REQUEST

Current Zoning: N1-C (neighborhood 1-C).
Proposed Zoning: N2-A(CD) (neighborhood 2-A, conditional)

Approximately 4.09 acres located along the north side of Hovis Road, west of Wildwood Avenue.

The petition proposes the development of up to 39 multi-family attached dwelling units. The site is currently undeveloped.

SCHEMATIC SITE PLAN

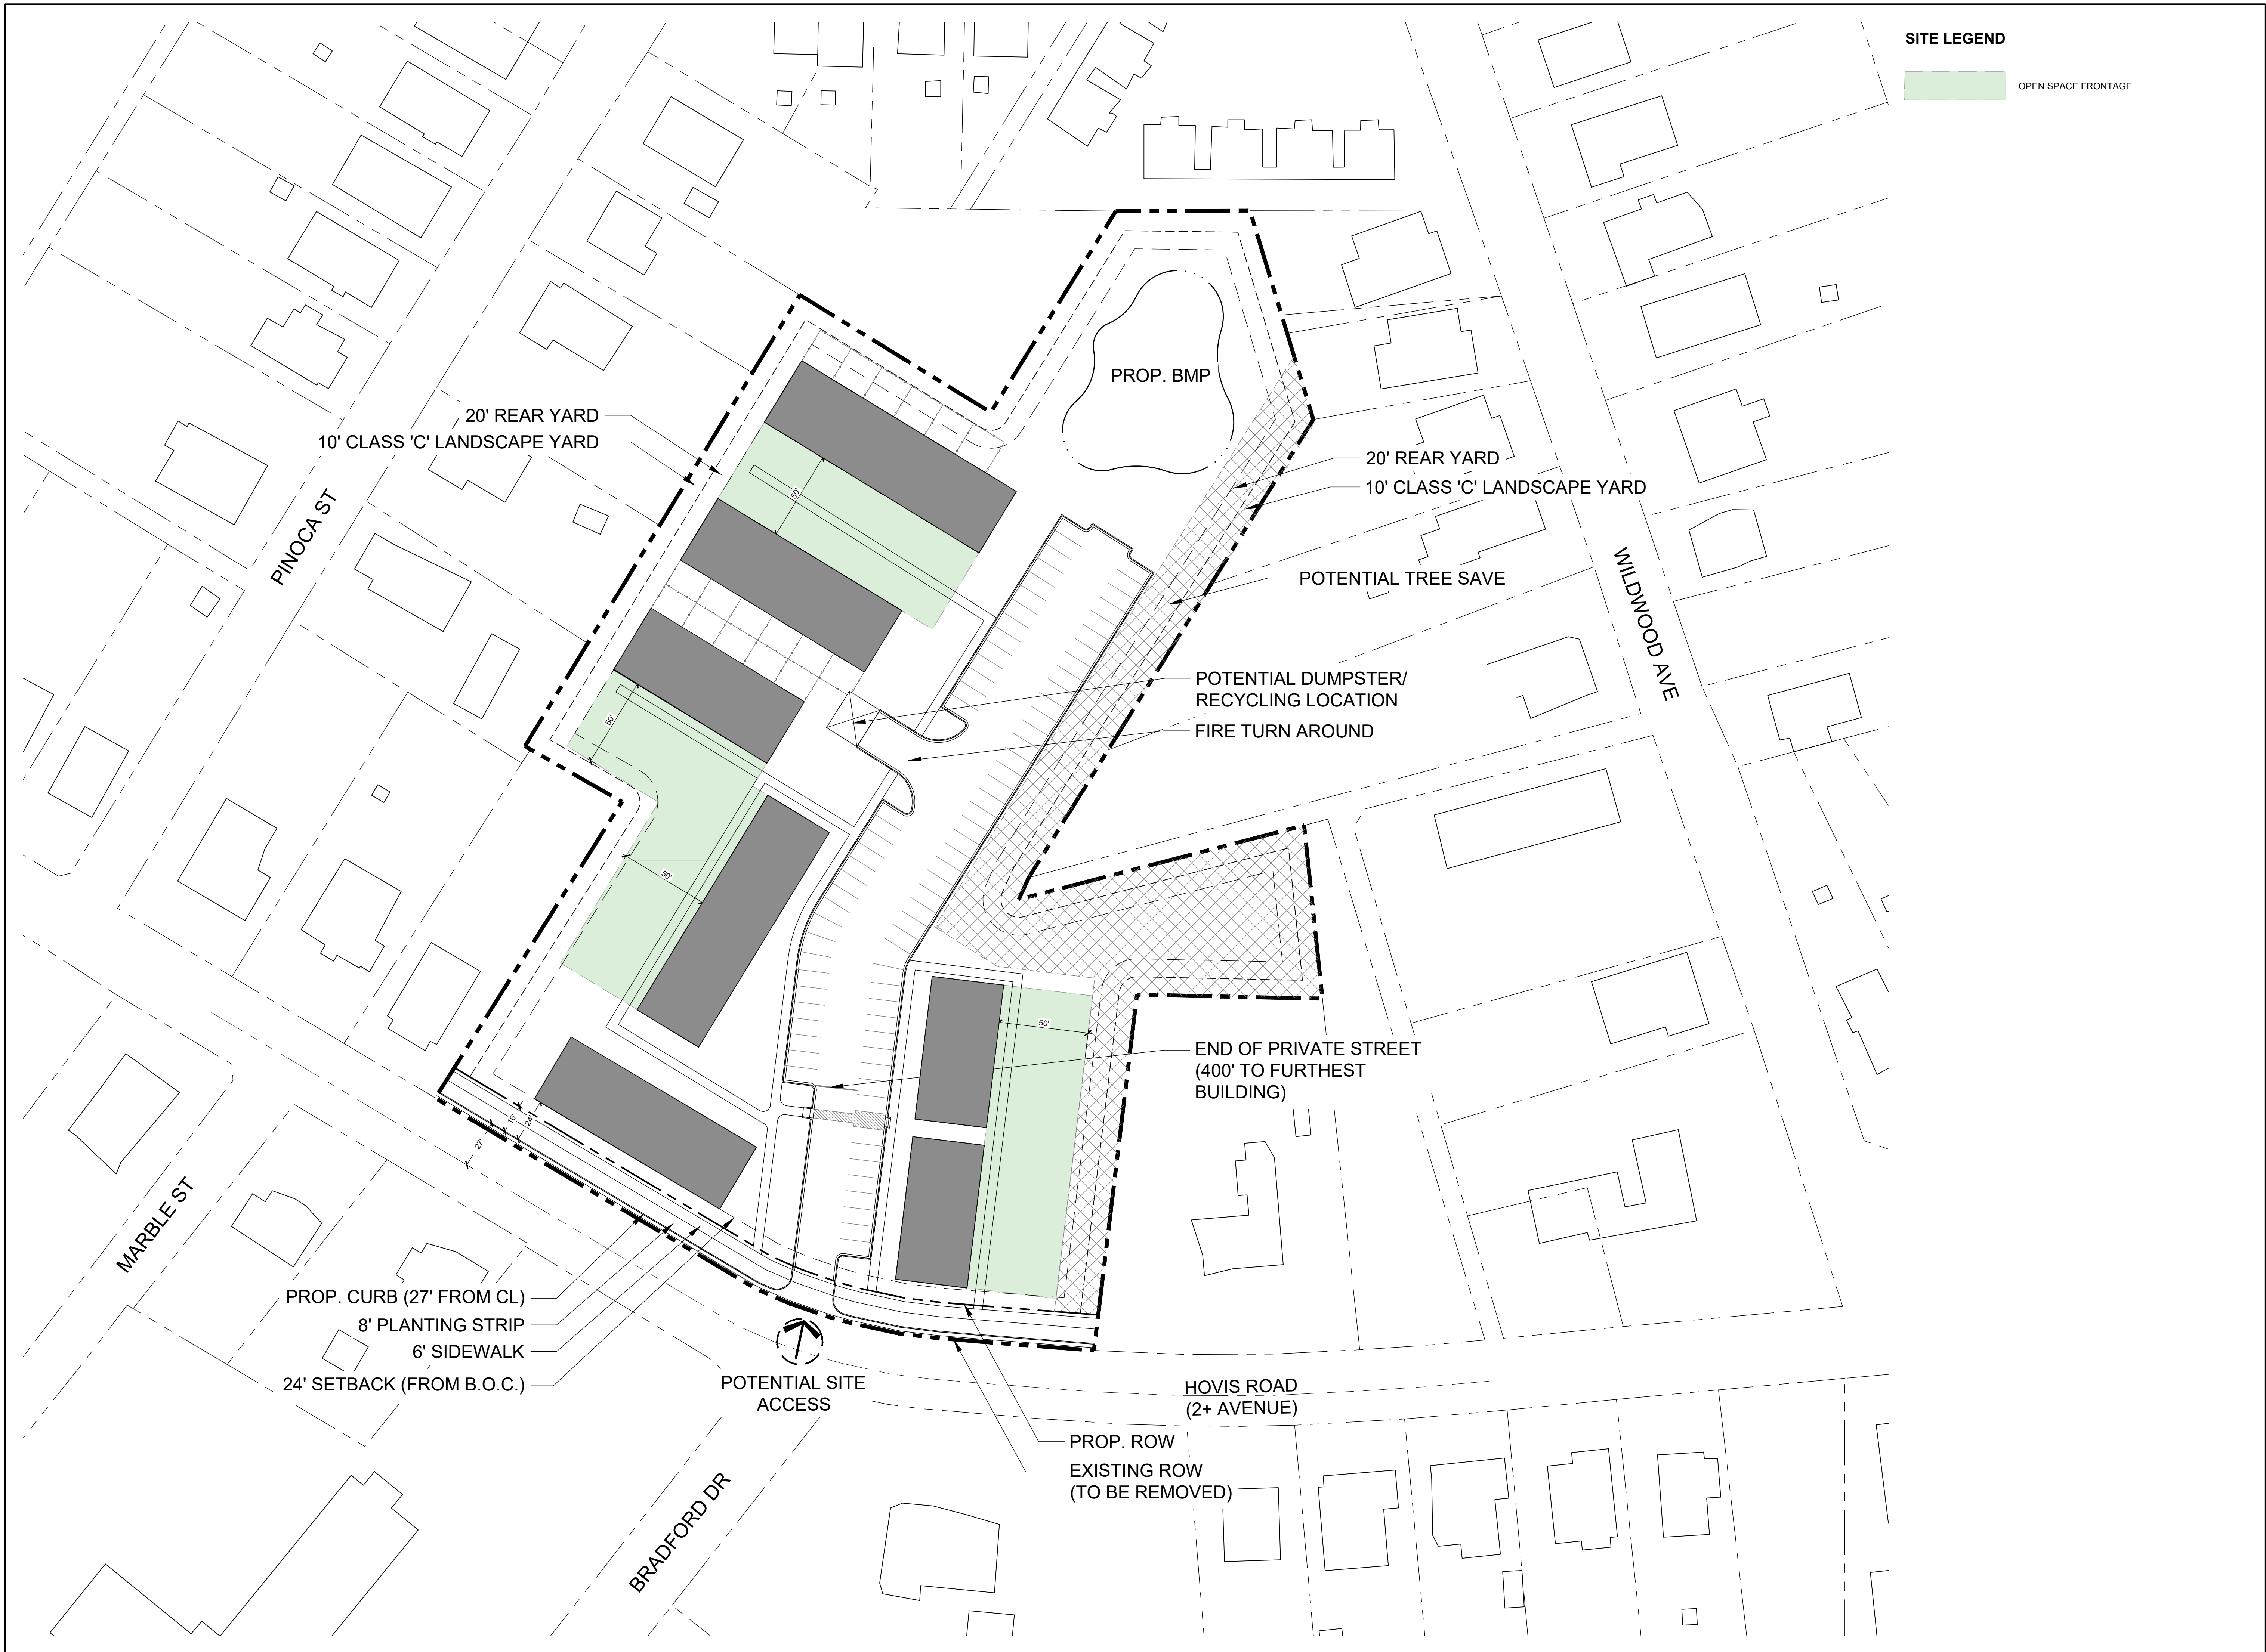
1. Urban Forestry: No trees are located in designated tree save/green area shown on site plan.

2. Housing and Neighborhood Services: under General Provision 3.a the proposed text "House CLT" should be amended to "House Charlotte Program"
 3. Entitlement Services: the large central parking area does not match the character of the neighborhood. The parking lot should be reconfigure to breakdown the scale of the parking.
 4. Entitlement Services: the height of buildings abutting properties in the Neighborhood 1 Place Type should be reduced to 40 feet.
-
